Subject: Rezoning Petition Review

Rezoning Petition #: 22-131

Location of Property: Approximately 35.26 acres located on the north and south side of Moores Chapel Rd, north of I-85 and west of Sam Wilson Rd.

RZ-2

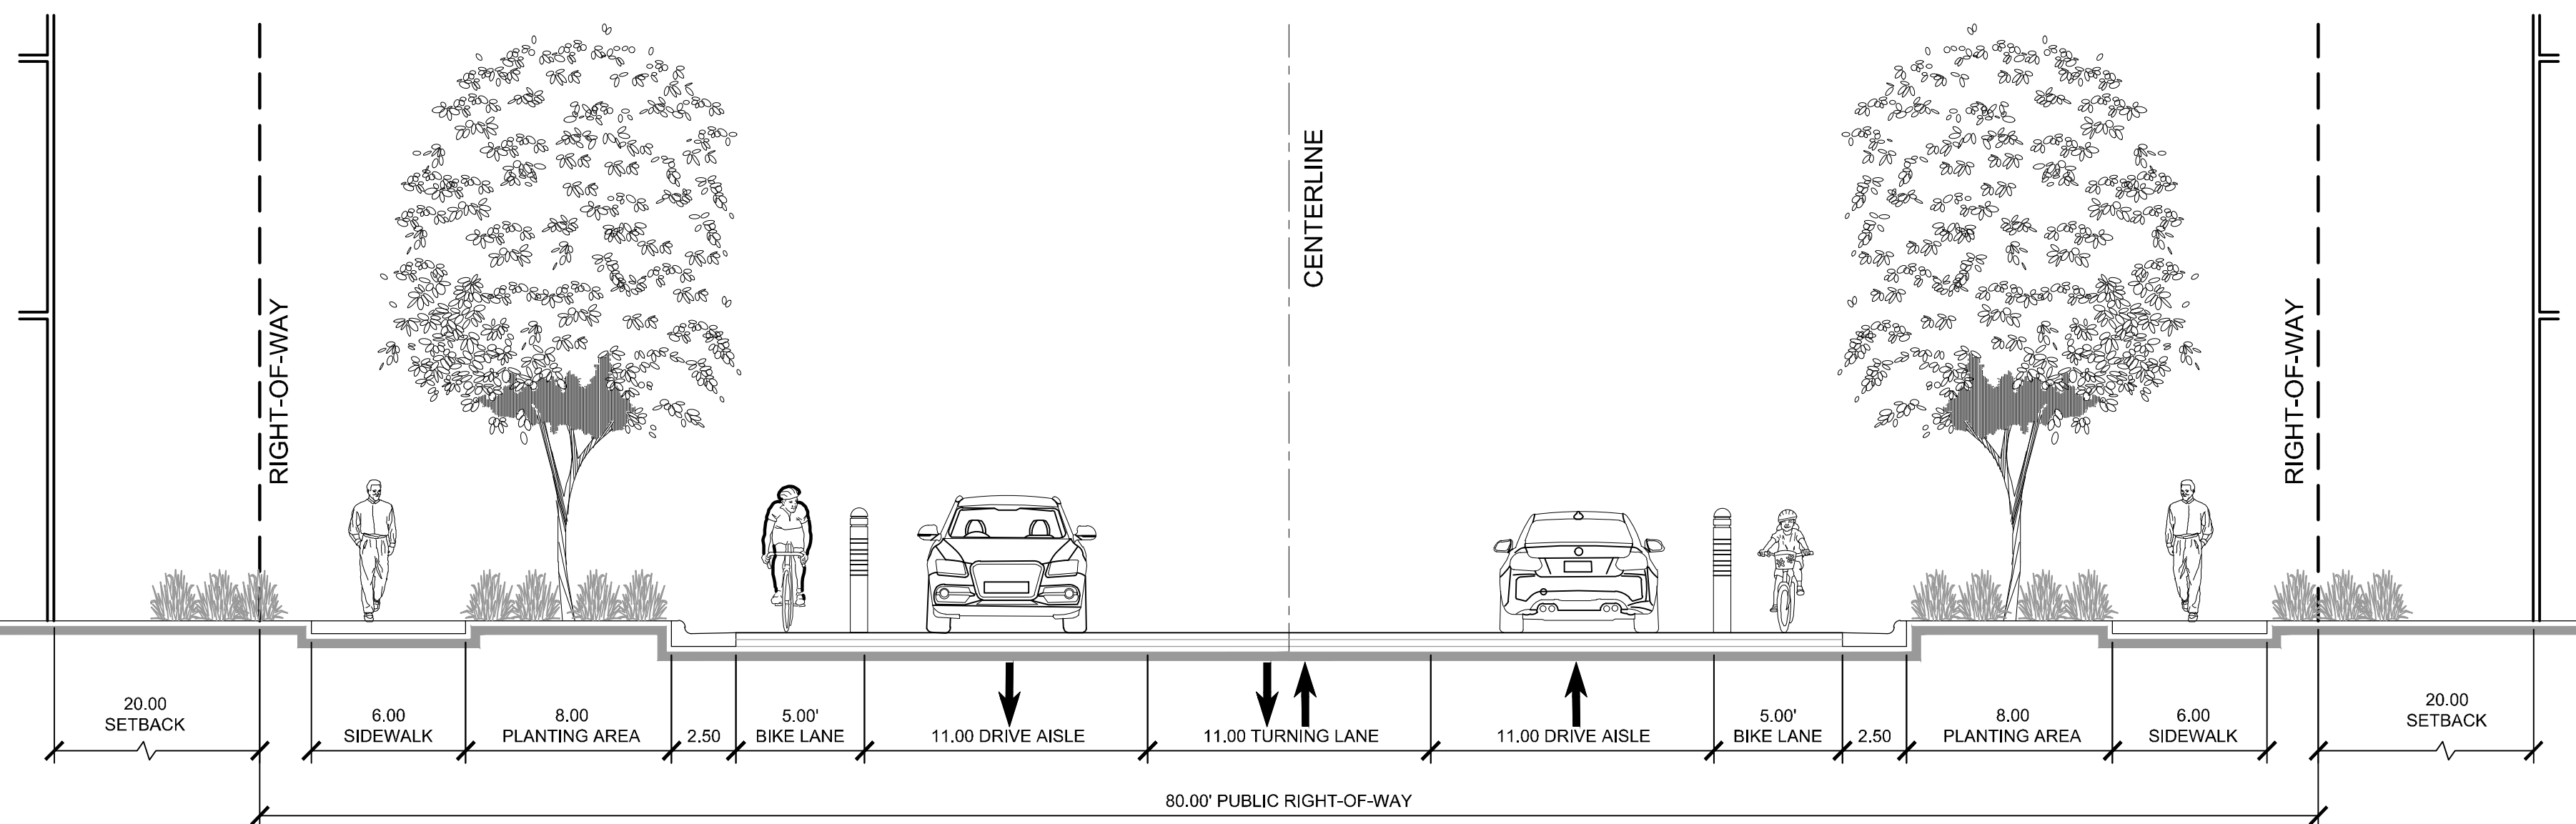
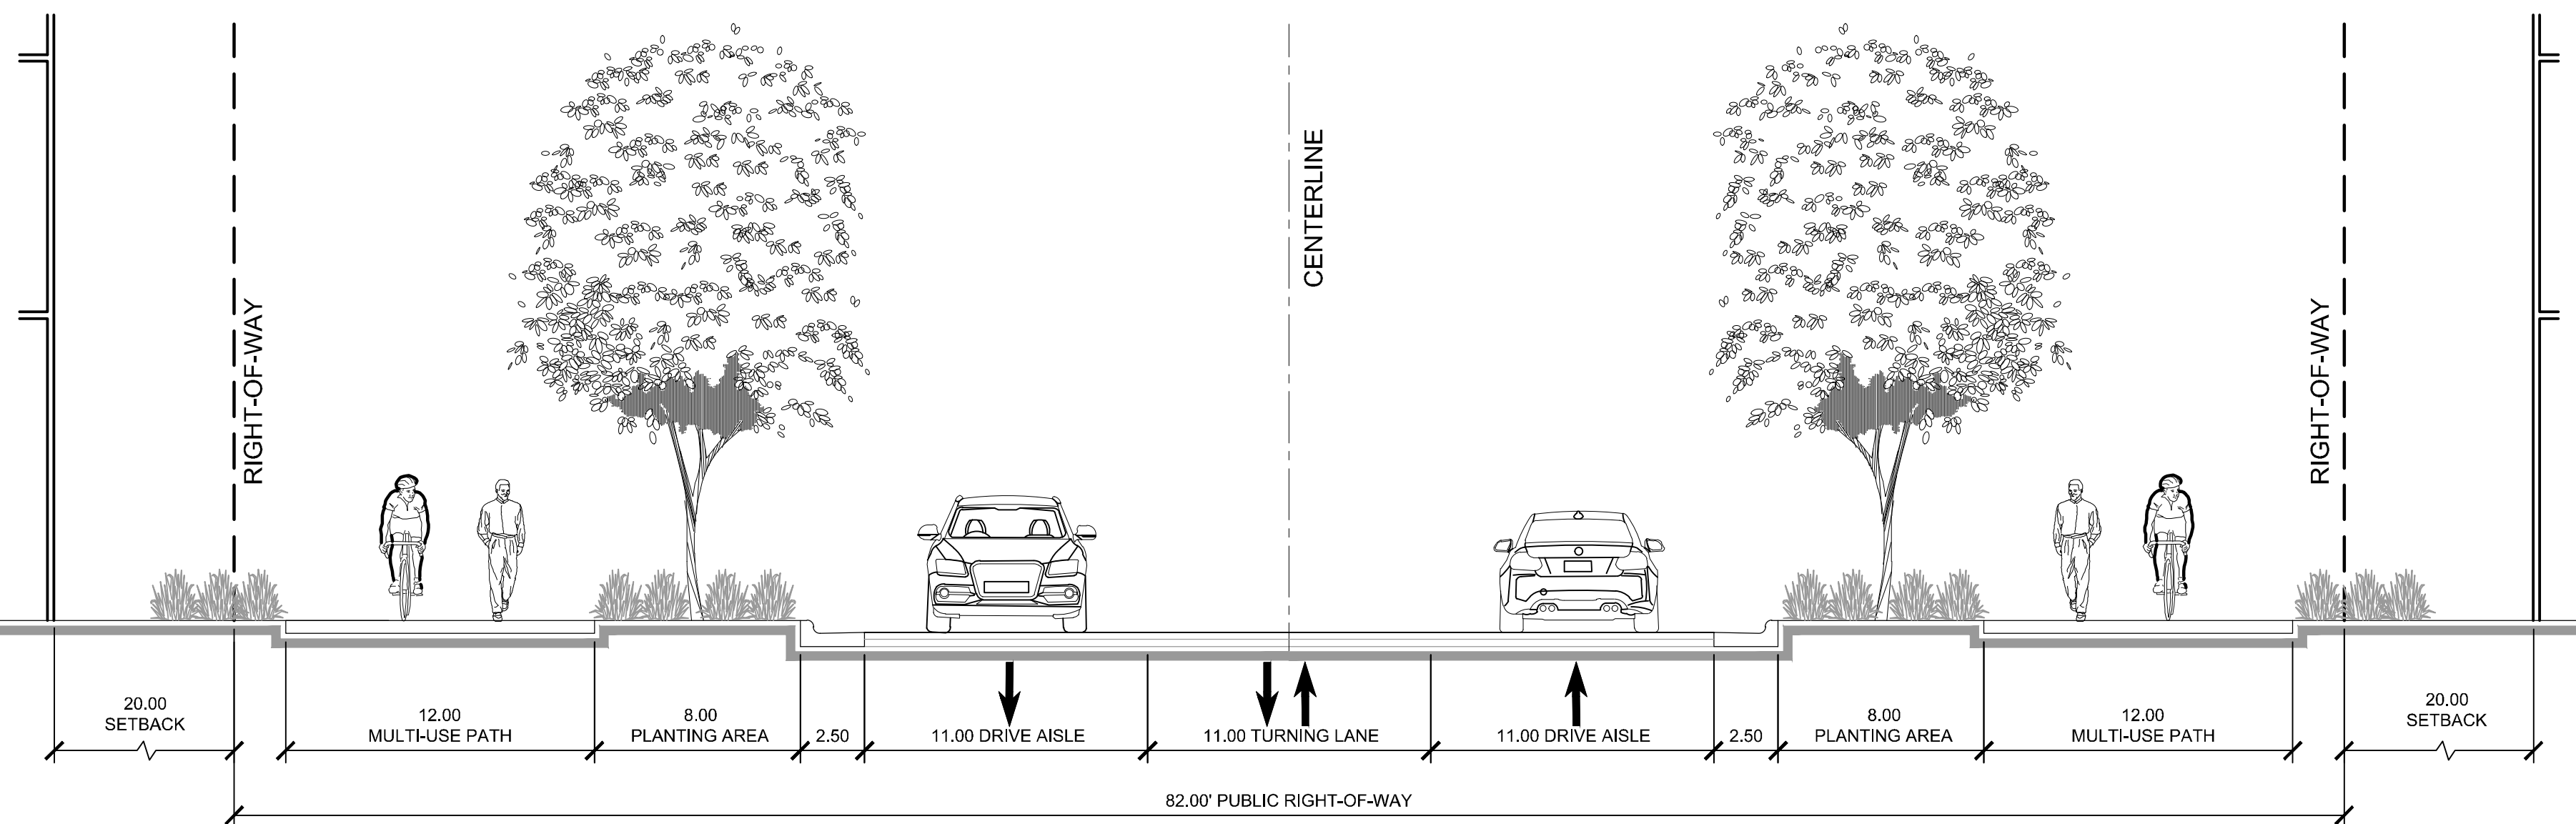
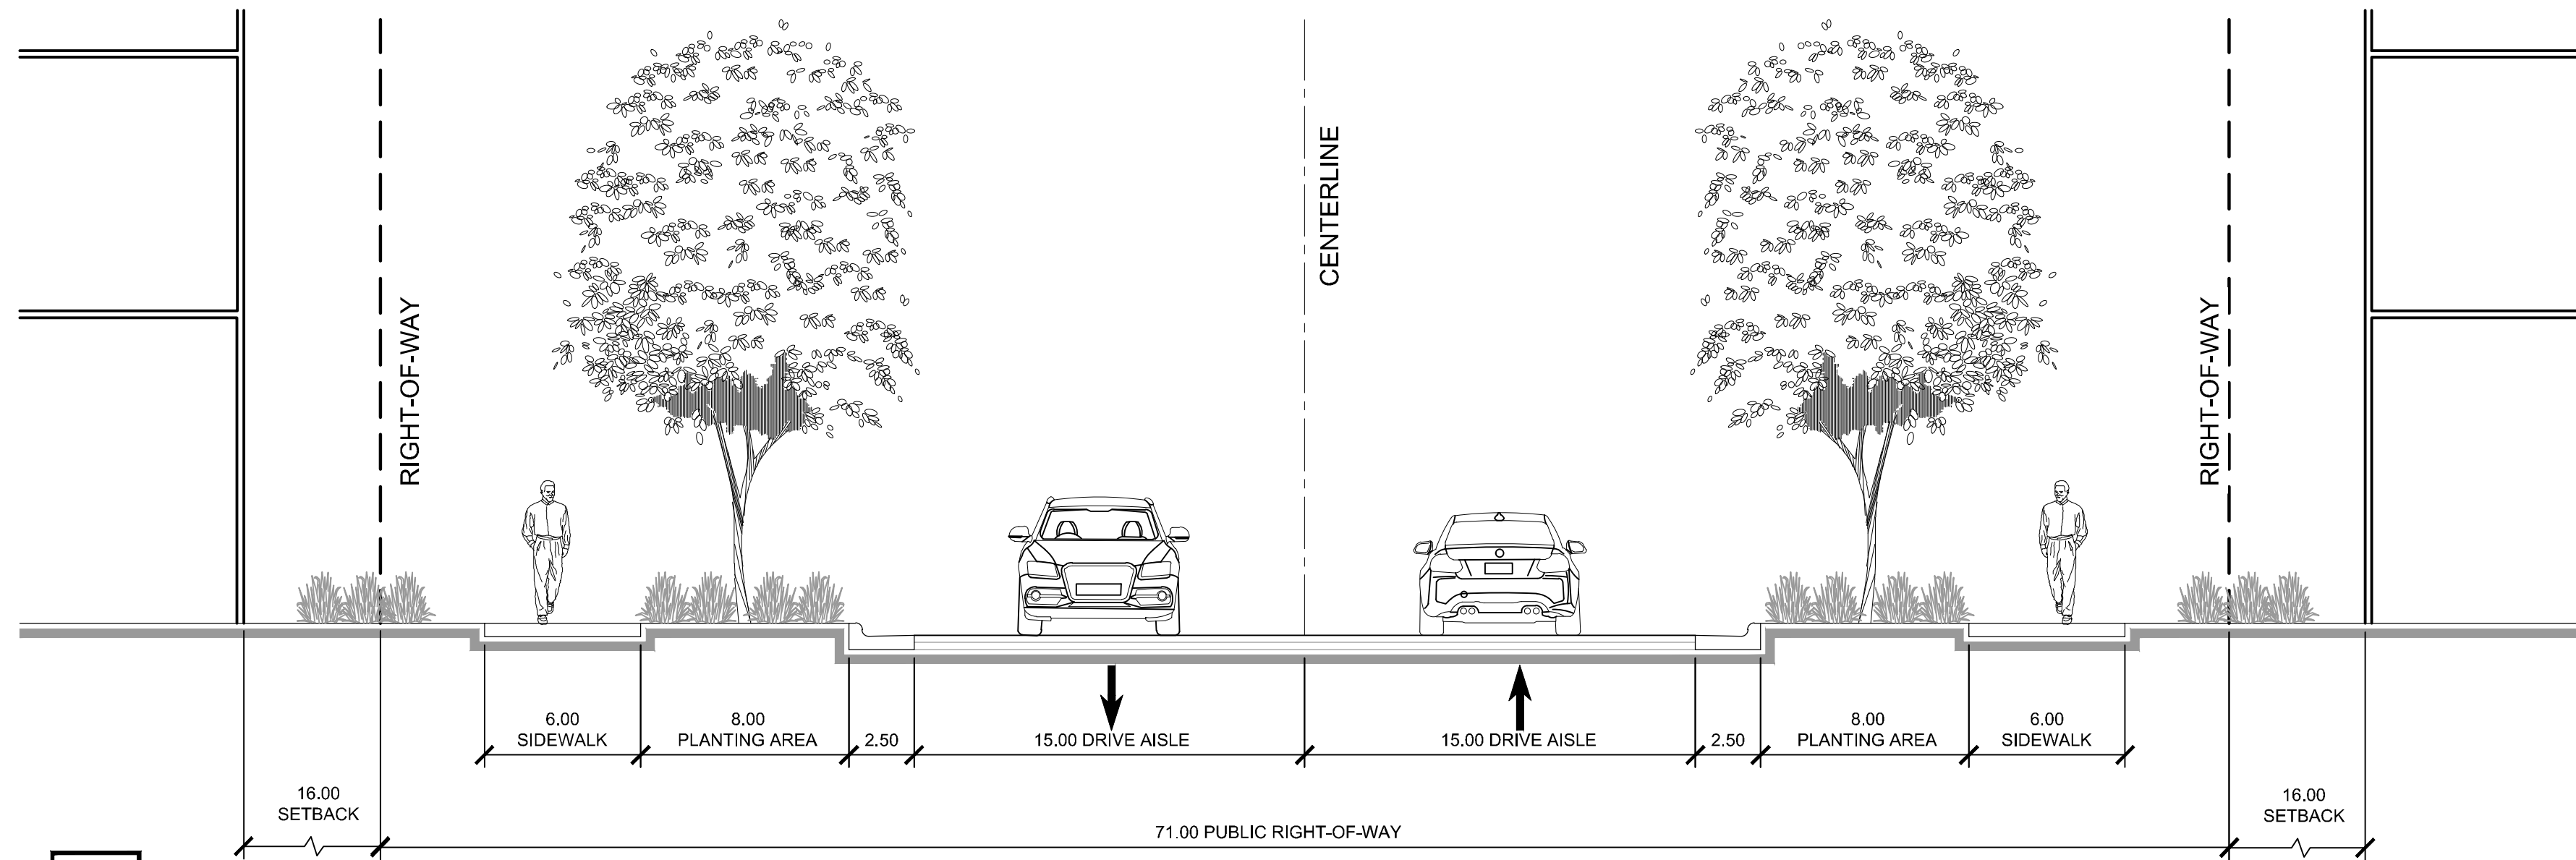
City of Charlotte GIS data indicates a 30-ft PCSO buffer across the site. Please show and label *Potential 30-ft PCSO Buffer* on the site plan. Any increase of impervious area within such buffers may not be allowed and is not approved with the rezoning process. Stream Delineation Reports are subject to review and approval by Charlotte Storm Water Services. Please include the following note under Environmental Features: *“Development within any SWIM/PCSO Buffer shall be coordinated with and subject to approval by Charlotte-Mecklenburg Storm Water Services and mitigated if required by City ordinance. Petitioner acknowledges intermittent/perennial stream delineation reports are subject to review and approval upon submission of development plans for permitting and are not approved with rezoning decisions.”*
